**Consultation Response from KC,
Highways Development Management**

2023/90831 63, West End Road, Golcar, Huddersfield, HD7 4JF

Demolition of existing garage and erection of two storey side extension, porch and replacement raised balcony to rear with alterations within a conservation area

Date Responded: 31/05/2023.

Proposed Site Layout
Scale 1:200

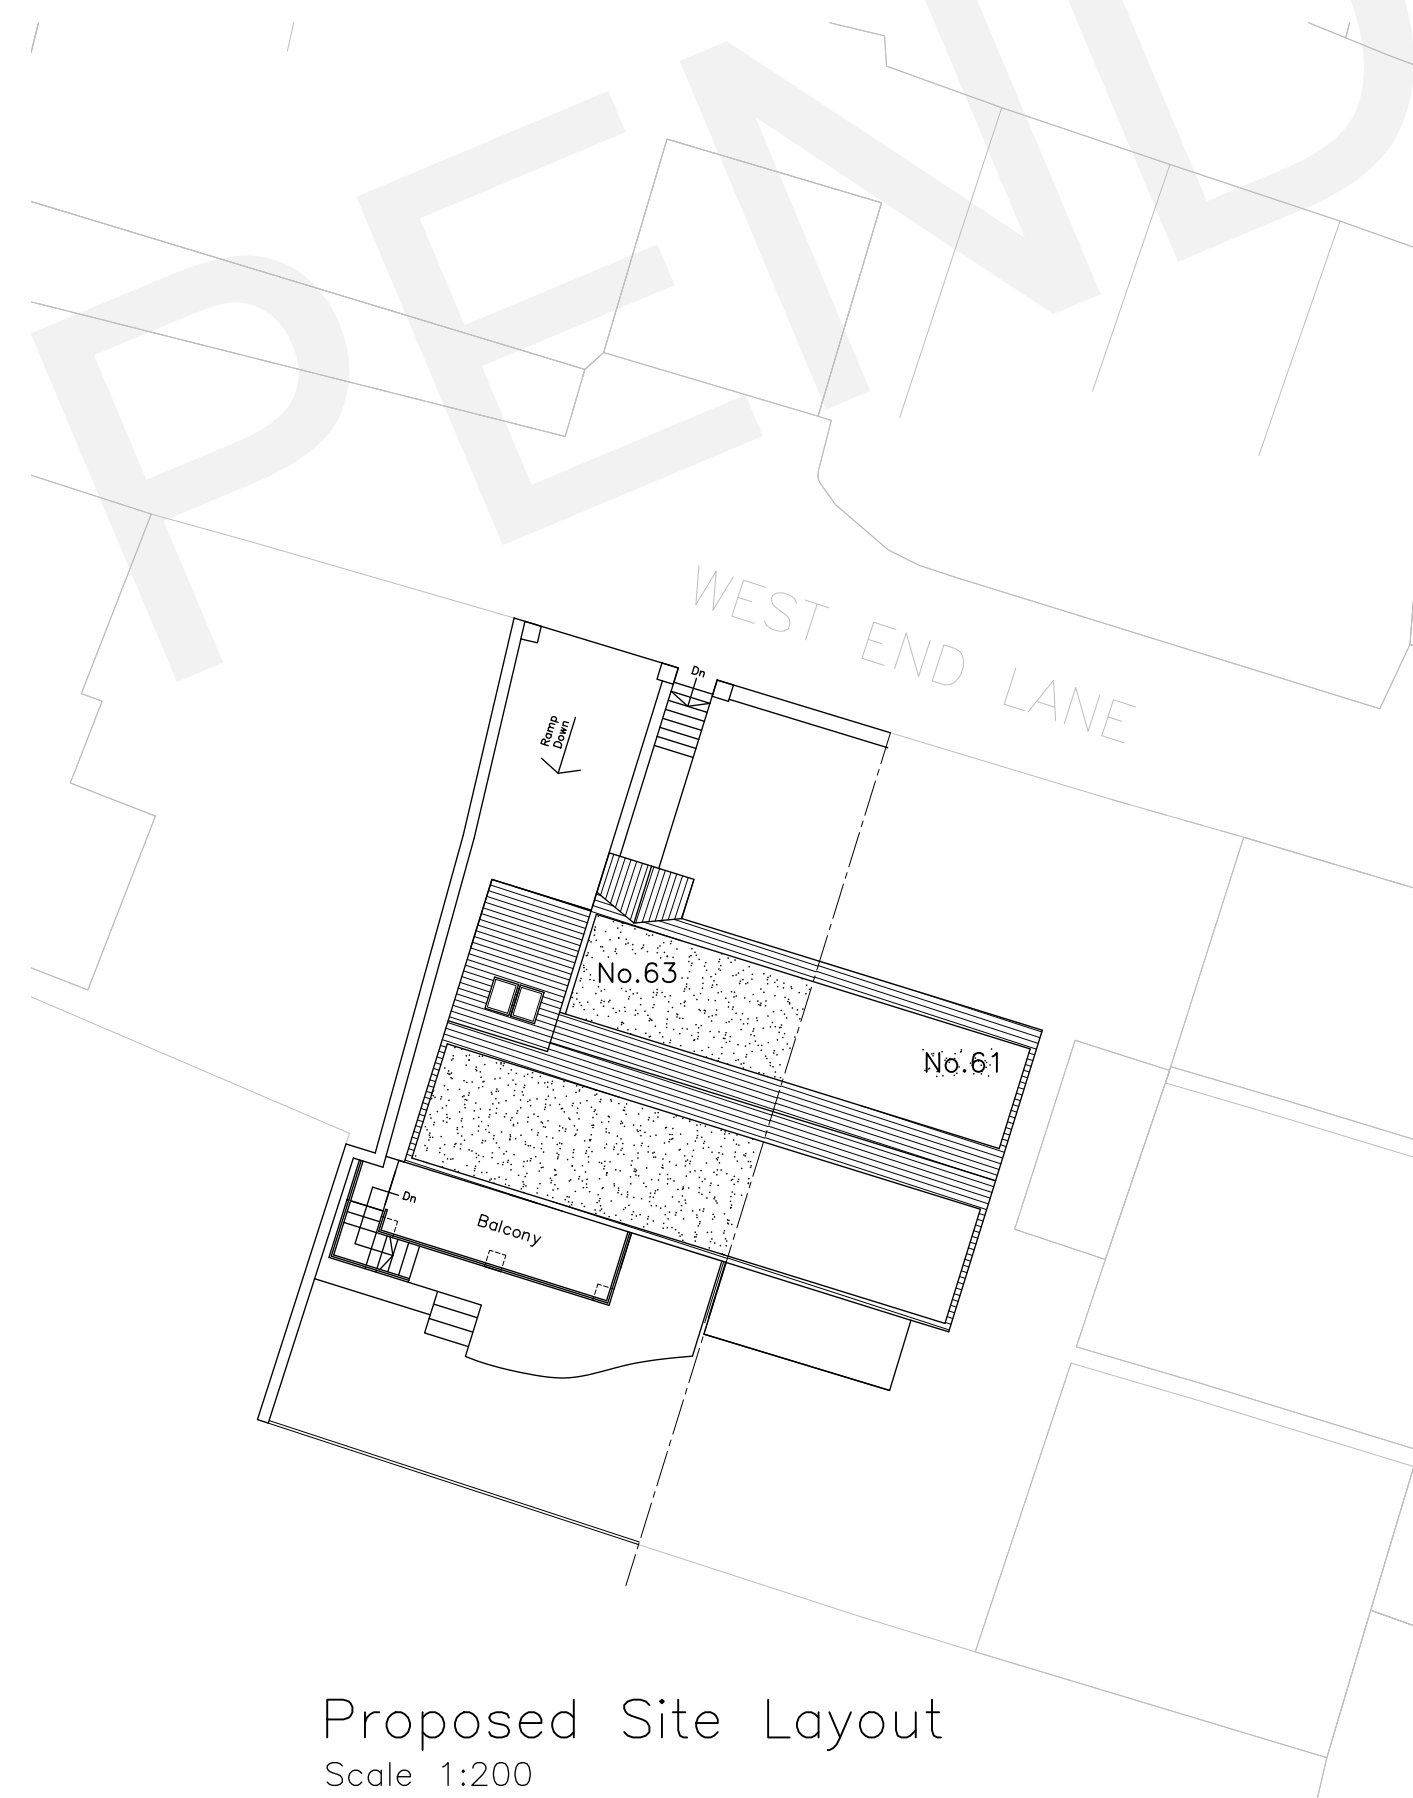
The existing property has provision for 2 off street parking spaces and the proposed extension will reduce the available parking on the site to 1 vehicle.

Normally Highways DM would not be able to support the reduction in parking provision as the Kirklees Highway Design Guide recommends that a 4+ bedroom dwelling provides a minimum of three off street parking spaces.

However, Planning Application Number 2022/93567 to provide an off-street parking area for 4 vehicles on land opposite the dwelling on West End Road was approved on 19th January 2023

As a result, Highways D M would have no objection to the proposal providing that the approved off-street parking area has been constructed and brought into use prior to this development commencing.

This should either be conditioned as part of this application or the red line boundary for this application should be extended to include the site of the proposed parking area.

No Objections subject to the off-street parking area, approved in application number 2022/93567 being constructed and brought into use prior to this development being commenced.
